RE: SSD 7603; Nos. 24-28 John Street and Nos. 4, 6, 8, 10, 12, 14, 16, 18, 20, 22, 24, 26 and 28 Board Street, Nos. 3, 5, 7, 11, 13, 15 and 17 Ann Street, Lidcombe 2141 NSW

I object to part of the abovementioned proposal, namely the above-ground multistorey carpark that will be constructed on Board and Ann Street. I have not included any objection to the proposed hotel in this submission. Internet hyperlinks have been included for your convenience.

2 ELEV_WEST
1 : 100

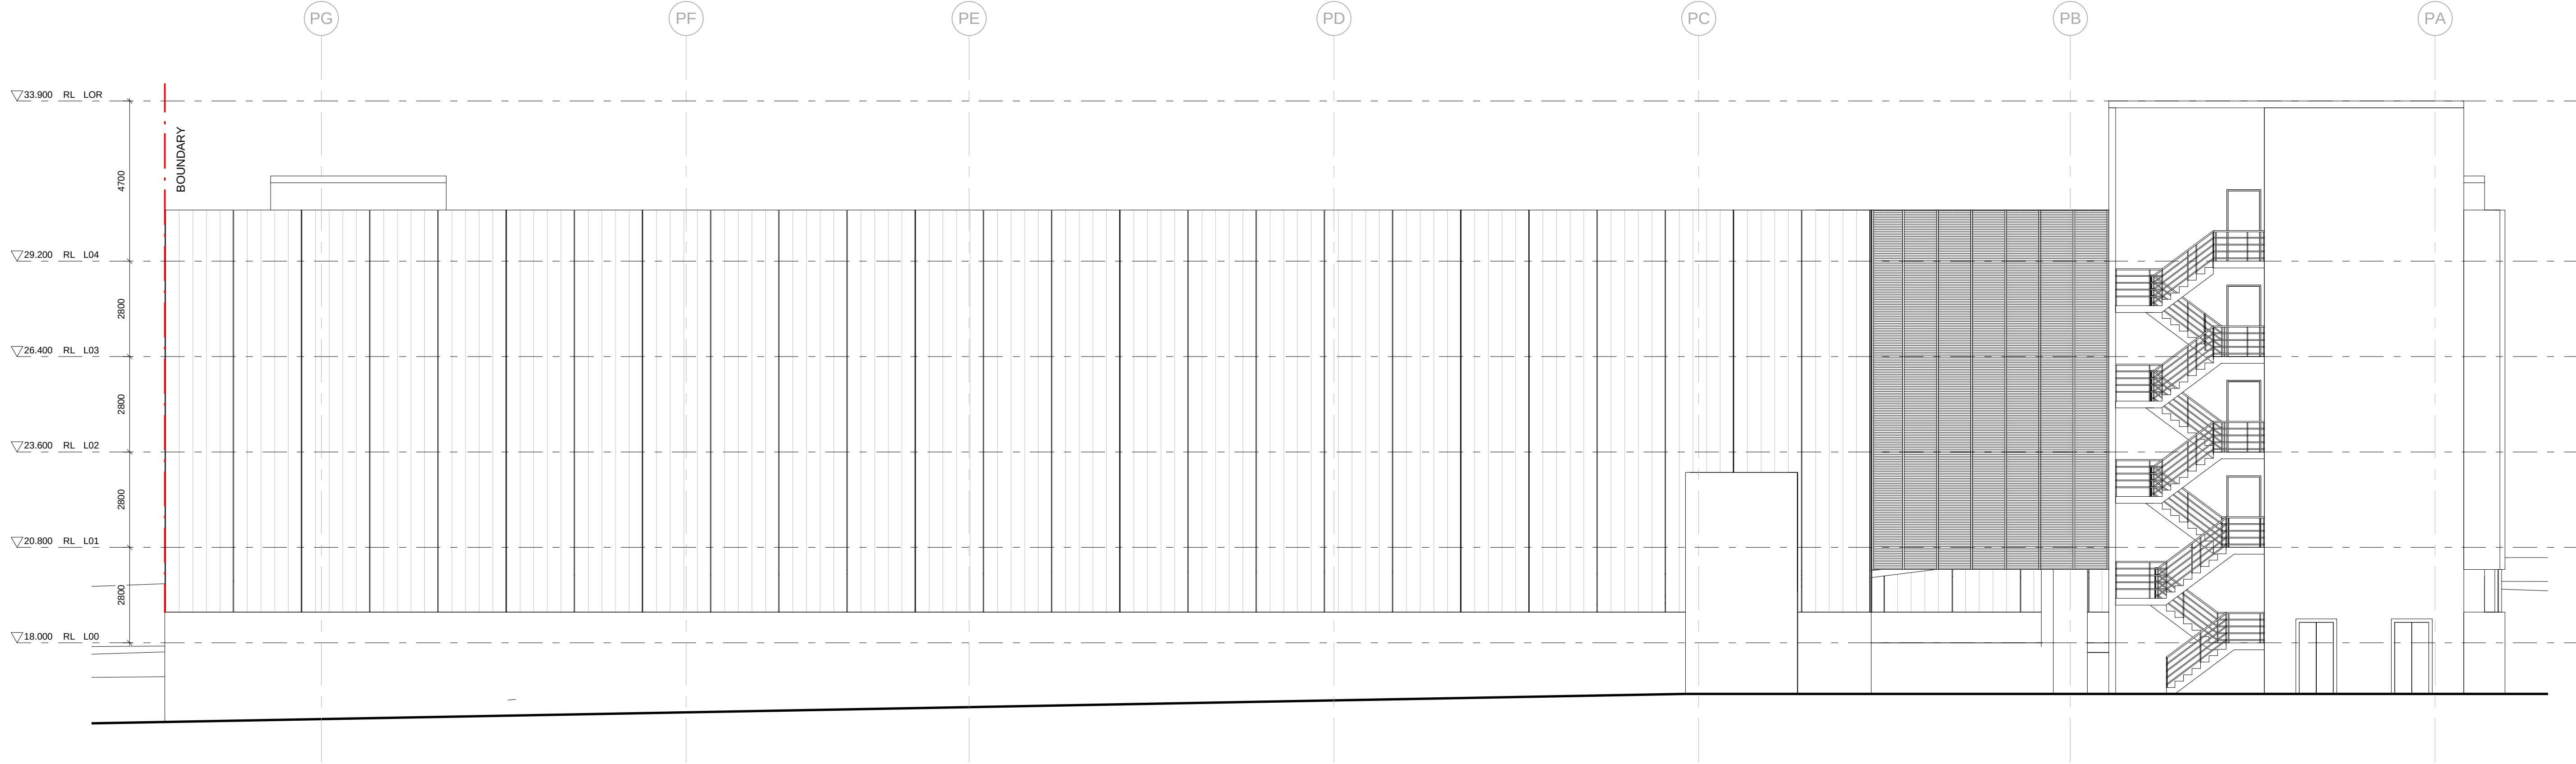
- C 2 Residential Interface** - the proposed carpark will be built much too close to my western boundary. My property would then be closely flanked on both my western and eastern boundaries by multistorey developments.

- I 3 Instead of the proposed boundary wall being built much higher than my single storey dwelling, build the boundary wall at or below the level of the *base* of the west-facing windows on my property.

- I 4 Ensure that the roof of the first storey of the carpark is no higher than the level of our ceiling of the west-facing rooms on my property.

- I 1 Instead of building so close to the boundary, setback the proposed multilevel carpark **at least 3 metres** from our common boundary.
- I 2 Instead of the current design with no stepping down, change the design of the carpark such that there is a **step-down**, with the higher storeys being closer to Olympic Drive than those closer to my property. In Figure 1, I have shown a situation where I would increase my solar access. The eastern wall of the first storey could be spaced at least 10 – 12 metres from the eastern wall of the second storey. The eastern wall of the second storey could be spaced at least 10 – 12 metres from the eastern wall of the remainder of the storeys.
